Charlotte Storm Water
600 East Fourth Street
Charlotte, N C 28202-2844

Rezoning Petition Review

Rezoning Petition #: 20-86

Location of Property: Approximately 71.94 acres located on the south side of University City Blvd, west of I-485 and north of Mineral Springs Rd.

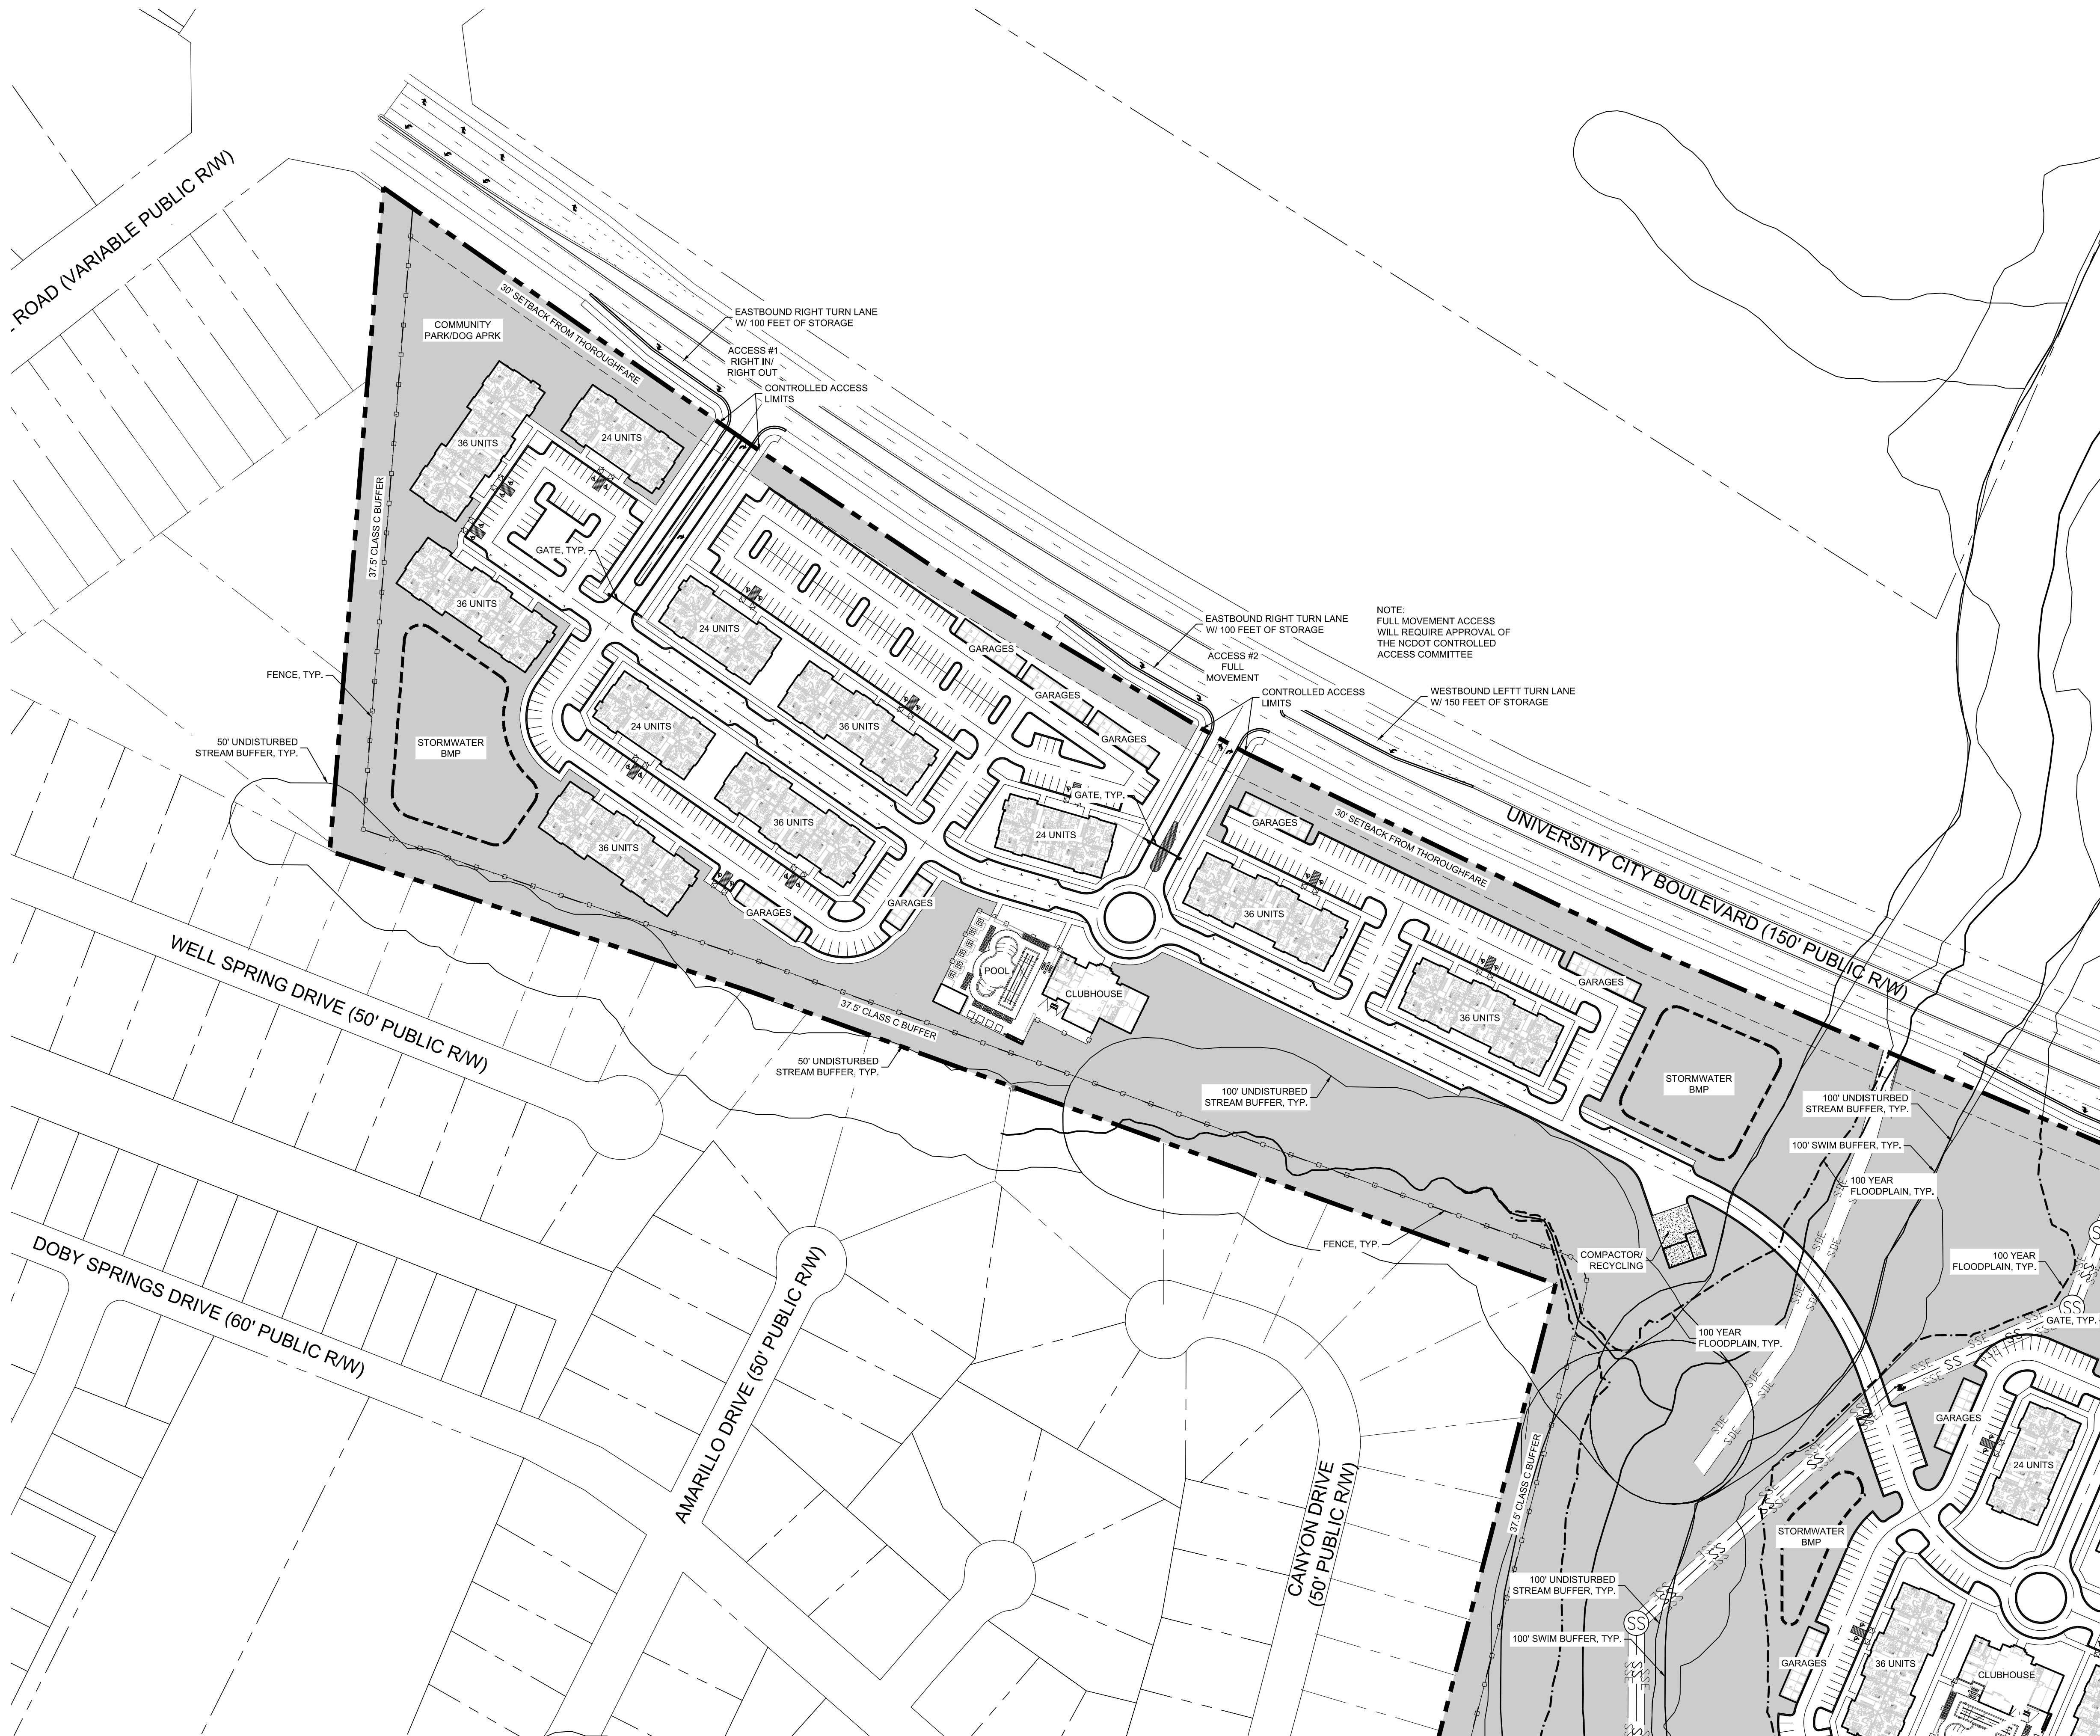
For adjoining parcels receiving storm water discharge, specifically the residential communities identified for the development portion on sheet RZ-3.1, the petitioner shall analyze the adequacy of the existing storm water conveyance on the adjoining parcels to the FEMA confluence. If the existing storm water conveyance on the adjoining parcels is found to be inadequate, the Petitioner shall make a good faith effort with the property owner(s) to improve the storm water conveyance or mitigate the storm water discharge onto

the adjoining parcels.
